# DRB CASE ACTION LOG (PREL & FINAL PLAT)

DRB Application No.: 06DRB-01654 (P&F) Project # 1004932  
Project Name: MONTE VISTA ADDITION  
Agent: Precision Surveys Phone No.: 856-5700

28. ~~**Project # 1004932**~~  
06DRB-01654 Minor-Prelim&Final Plat  
Approval

Plat of
 Lot B-1, Block 5
Monte Vista Addition
 Albuquerque, Bernalillo County, New Mexico
 November 2006

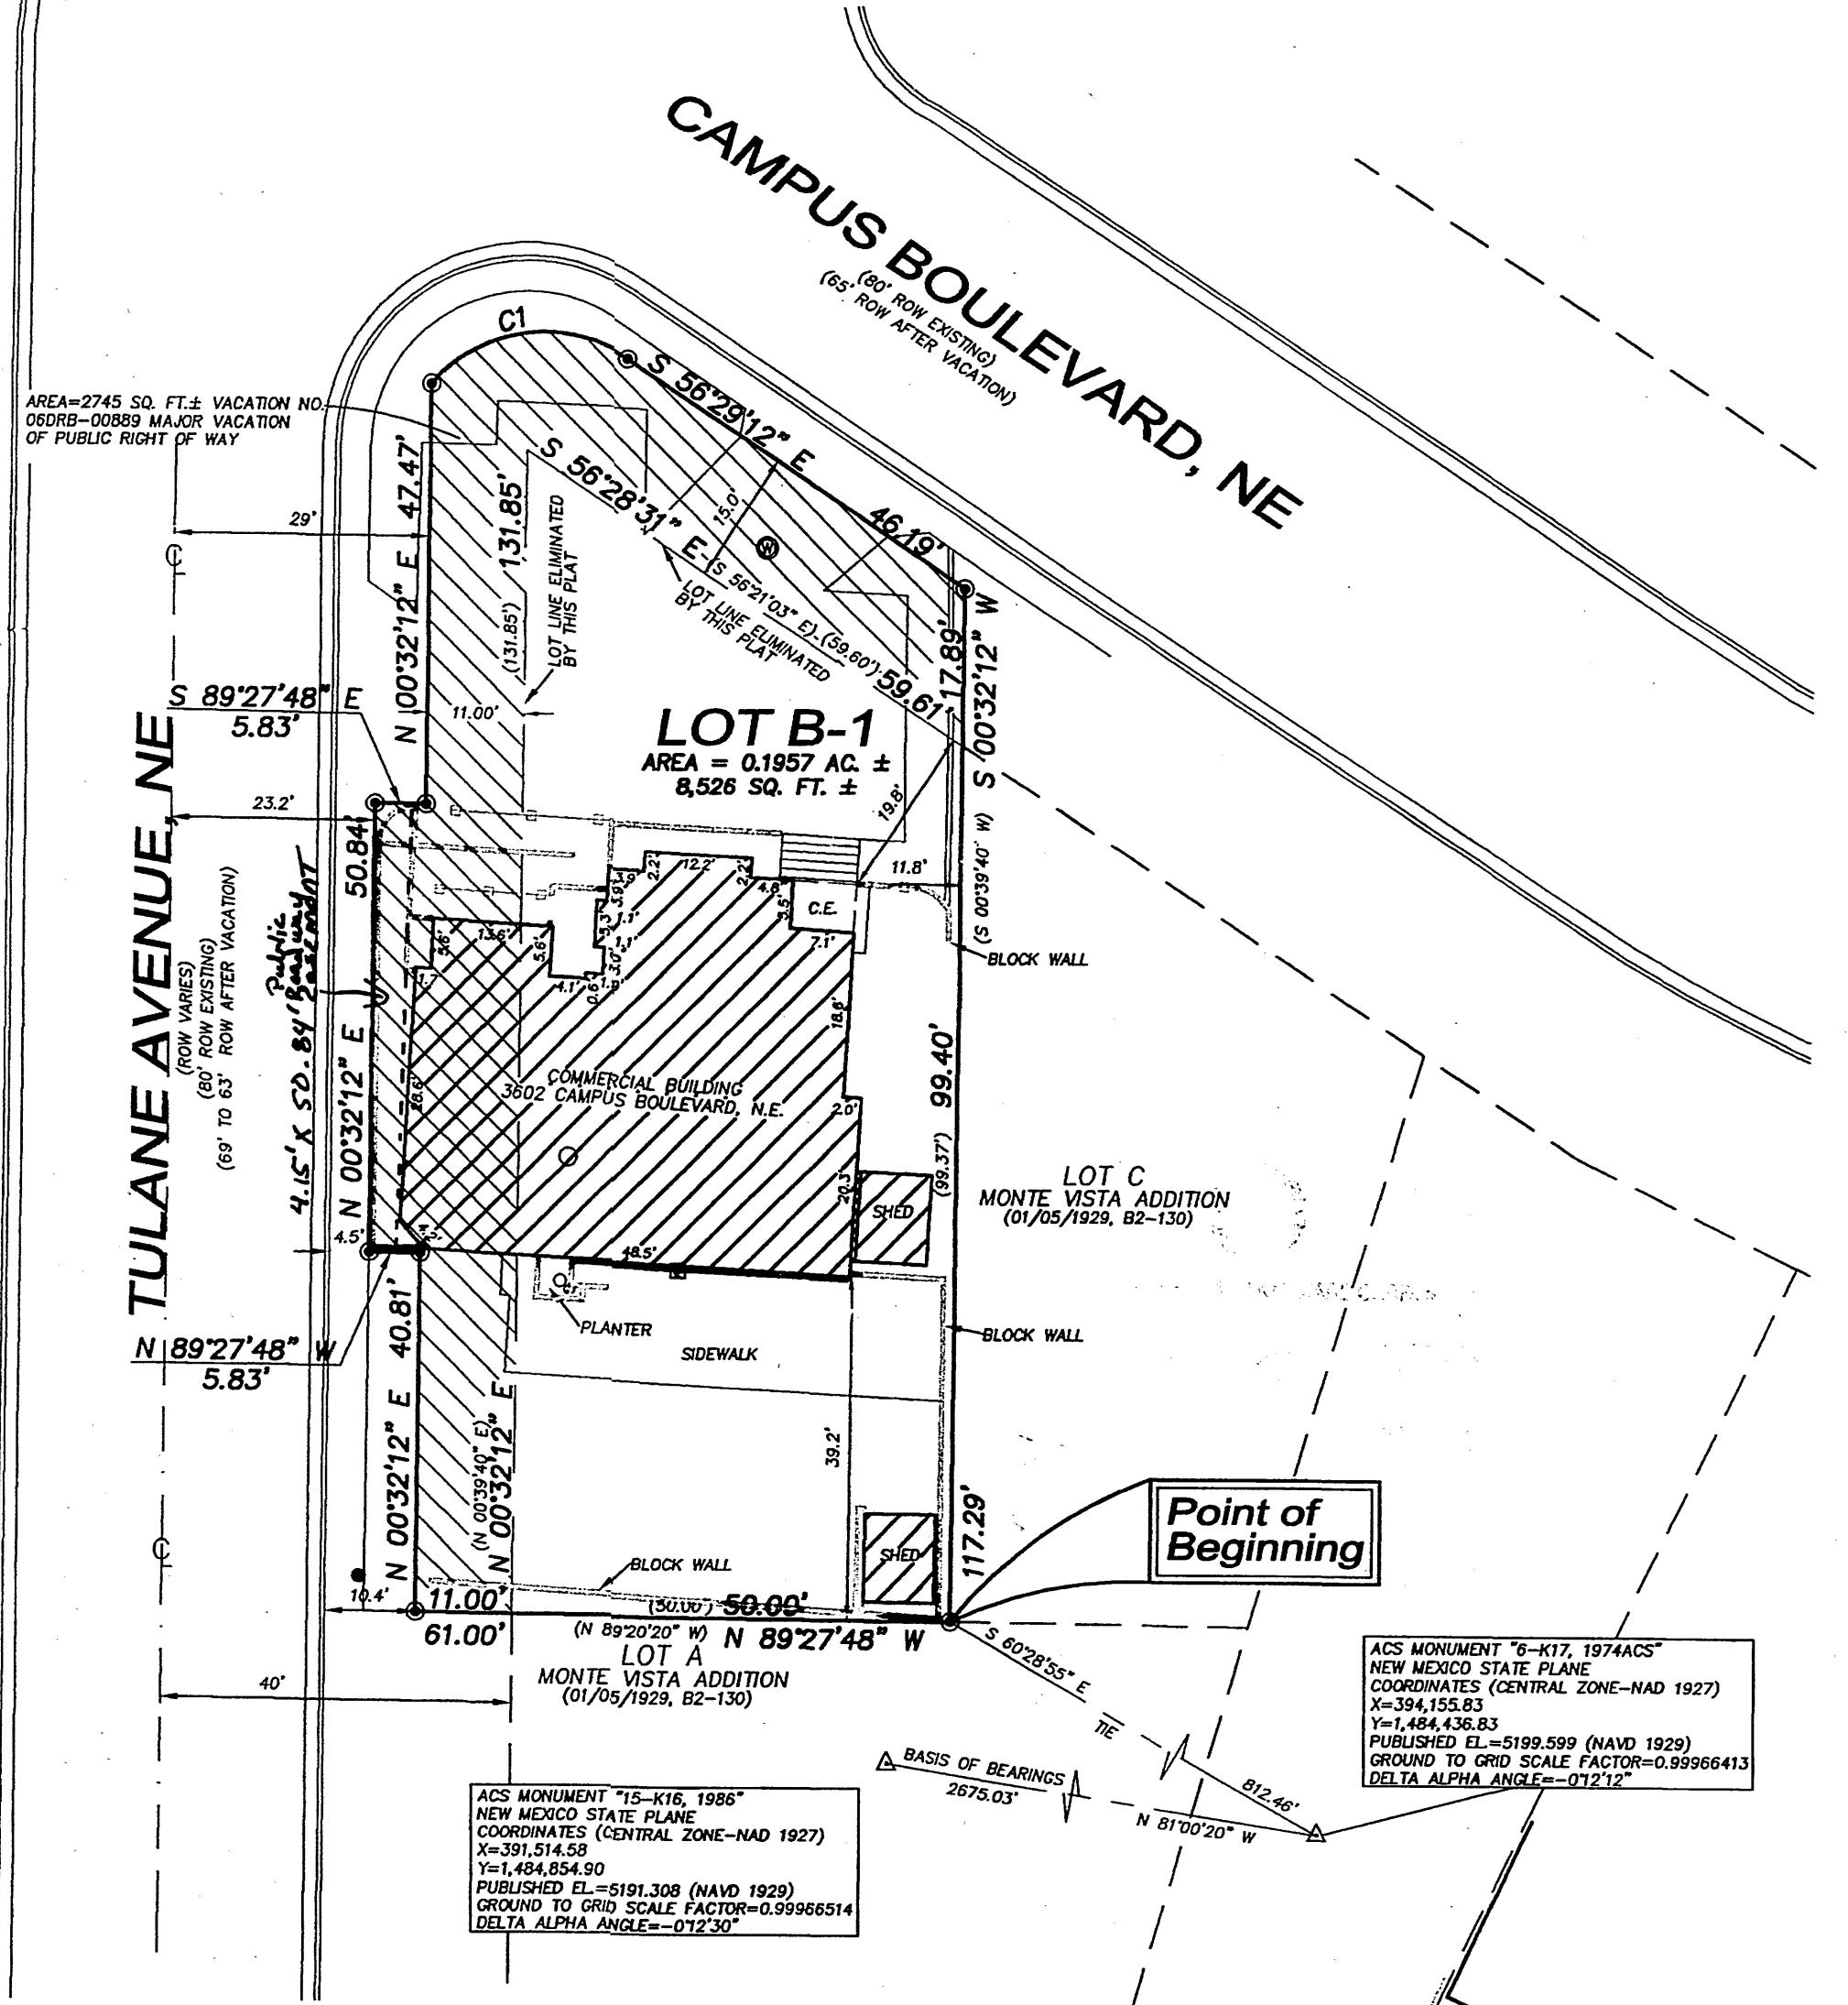
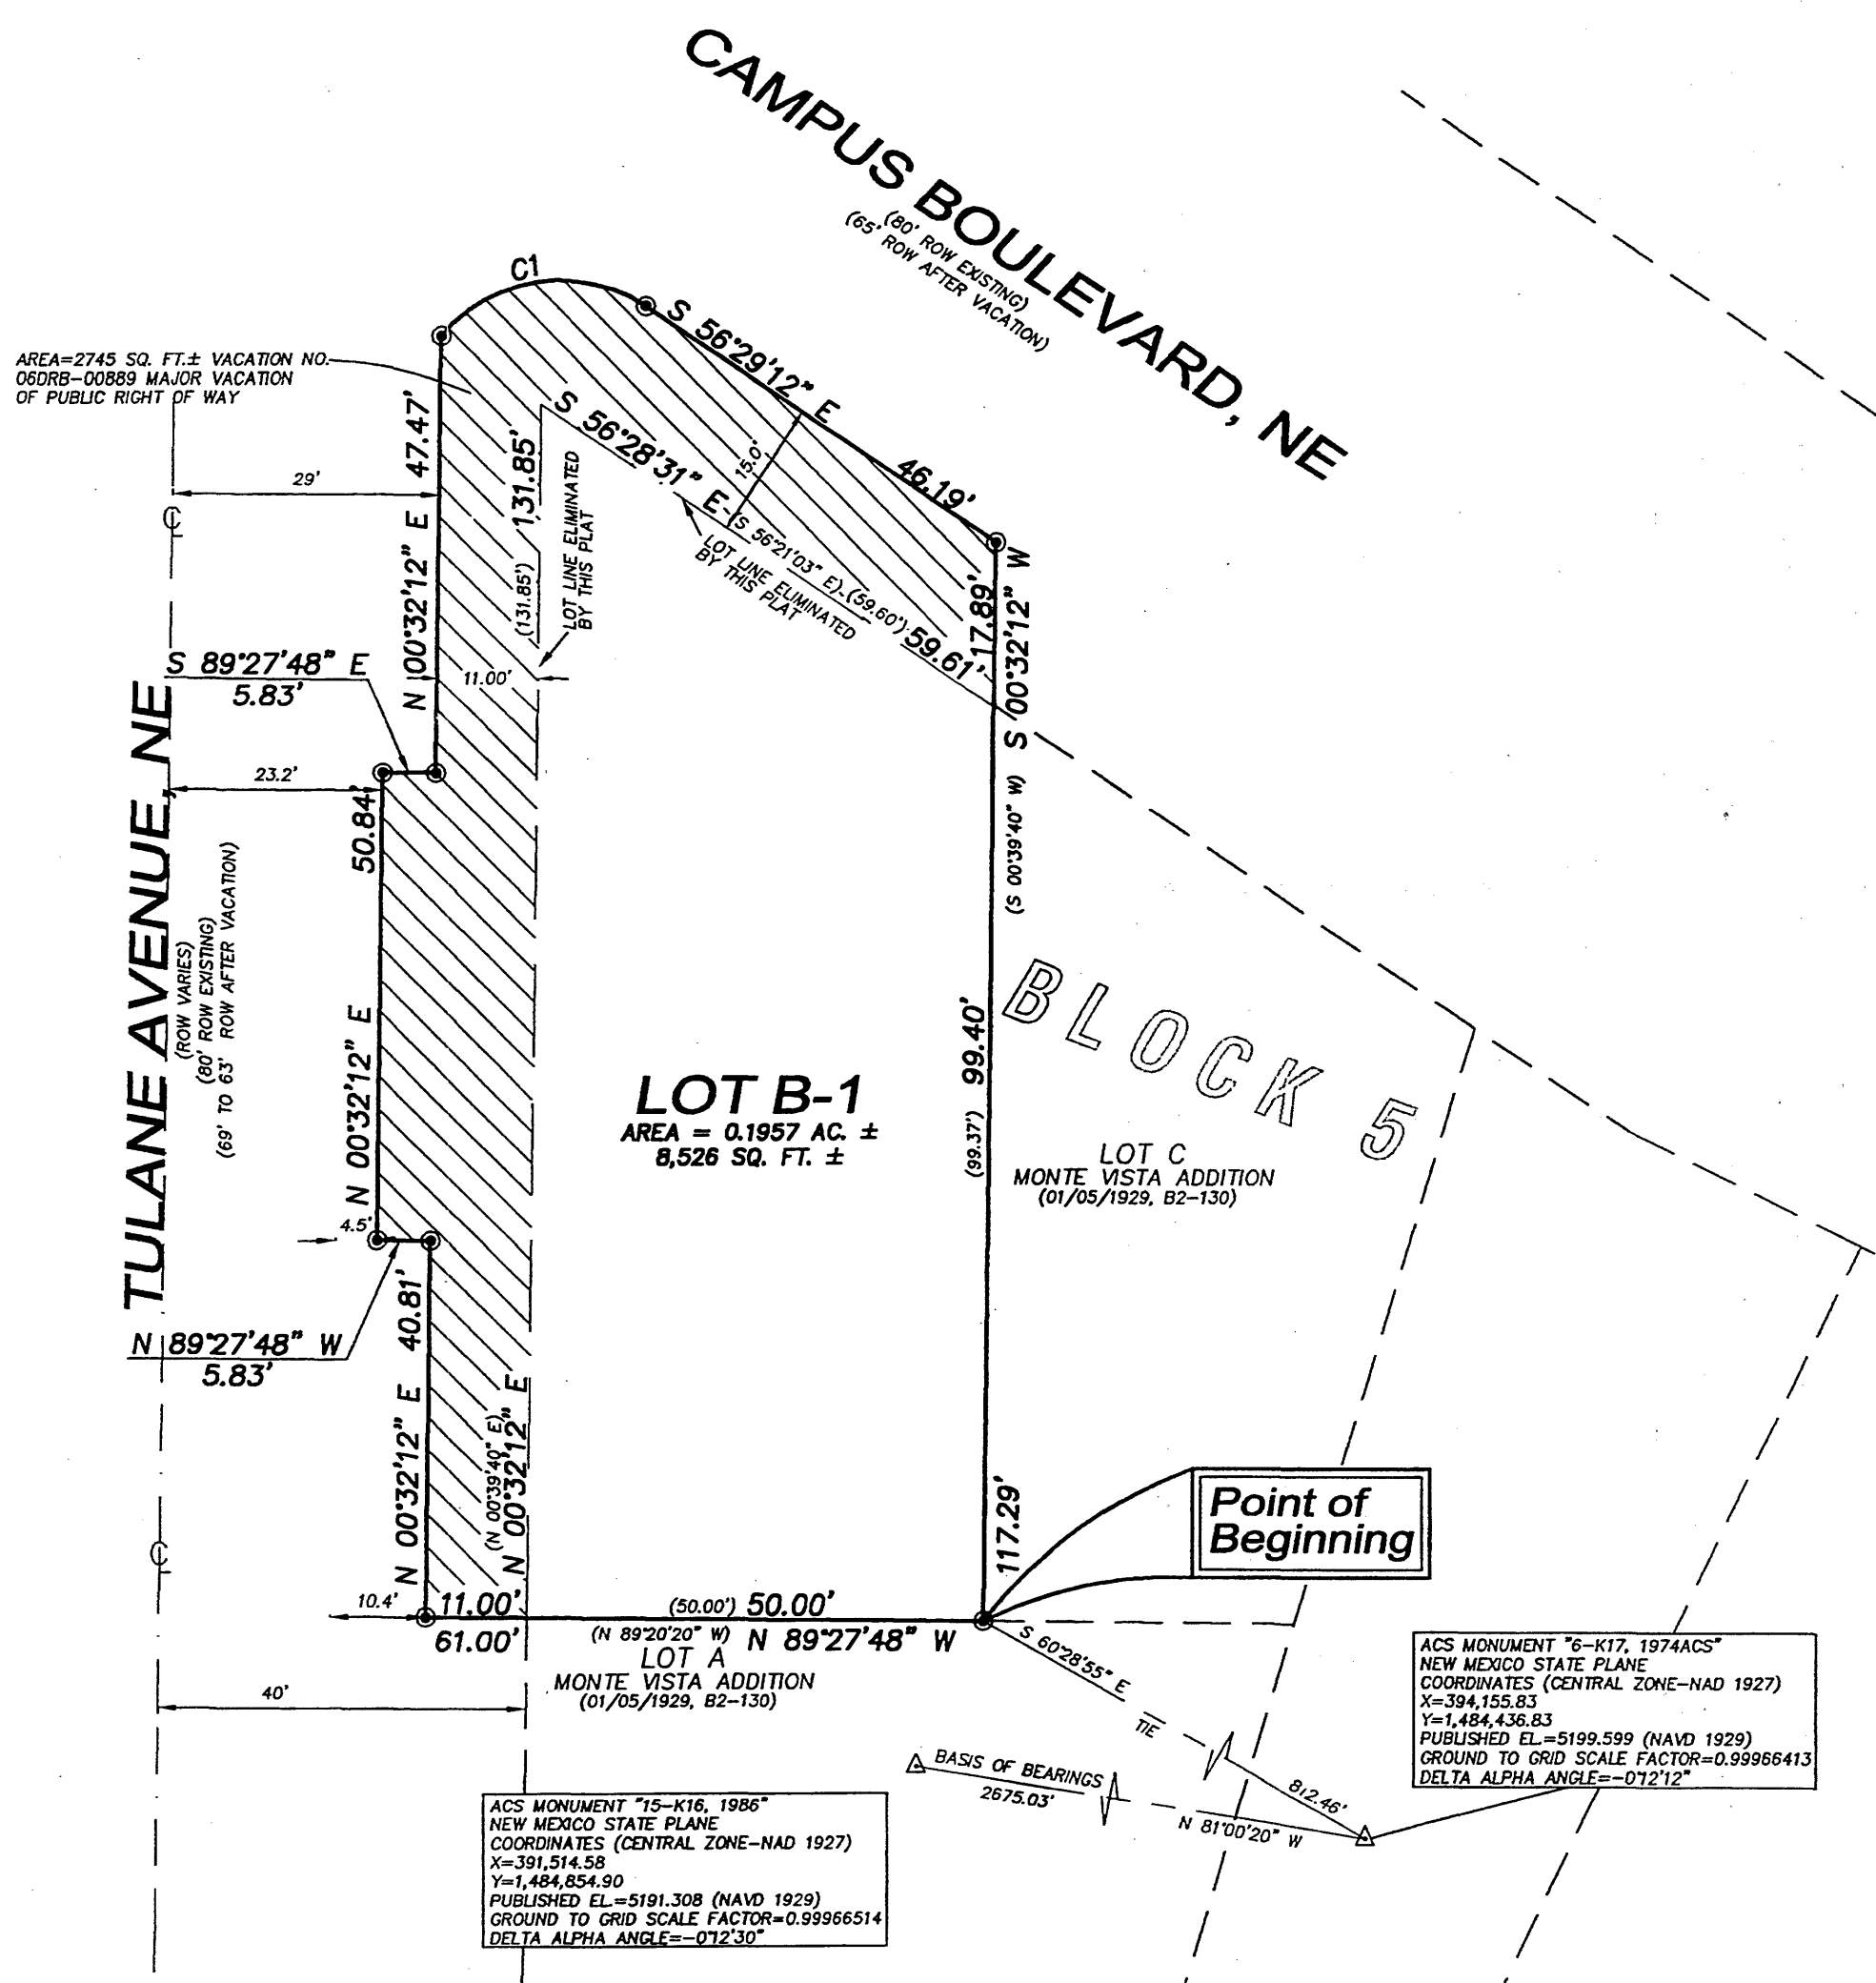
- TRANSPORTATION: — Plat need to show 11' of VTCATED  
R/W
- 
- 
- 
- 
- UTILITIES: \_\_\_\_\_
- 
- 
- 
- CITY ENGINEER / AMAFCA: \_\_\_\_\_
- 
- 
- 
- PARKS / CIP: \_\_\_\_\_
- 
- 
- 
- PLANNING (Last to sign): AGIS DXF re-approval  
real property signature of Ag 7/11/07  
record
